**Notice of Exhibition
Light Horse Interchange Business Hub, Eastern Creek (SSD 9667)**

Objective reference: CD19/06422

Attachment A: Detailed comments on SSD 9667

Figure 4: Pedestrian / Cyclist Access & Circulation (background source: Cycleway Finder - NSW Transport - RMS)

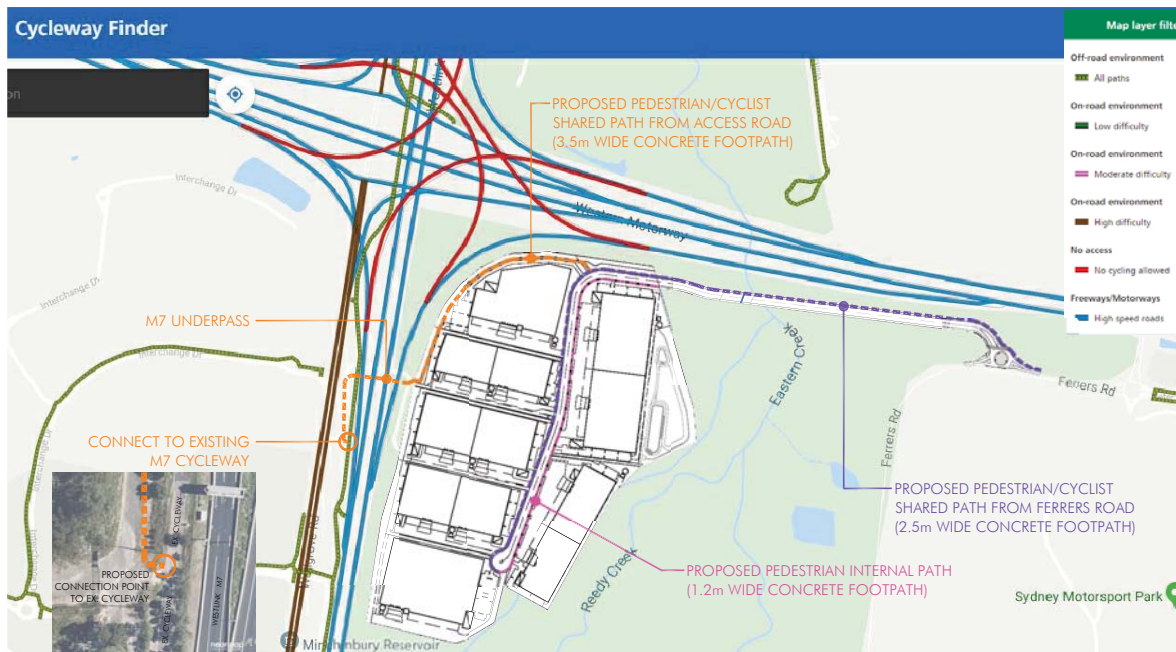
It is unclear within the project description (Section 2.3 of the EIS) as to whether the proposal includes construction of a suitable cycleway link between the site shared path and connection to M7 shared path. This link would ensure a continuous connection and experience for future employees seeking to cycle to work at the site and other businesses to the east of the site.

The Applicant should clarify within the project description as to whether the proposal includes the construction of a cycleway link between the site and the M7 shared path. If there is no proposal to complete the link, then it is recommended that the Applicant should include it within the project description.
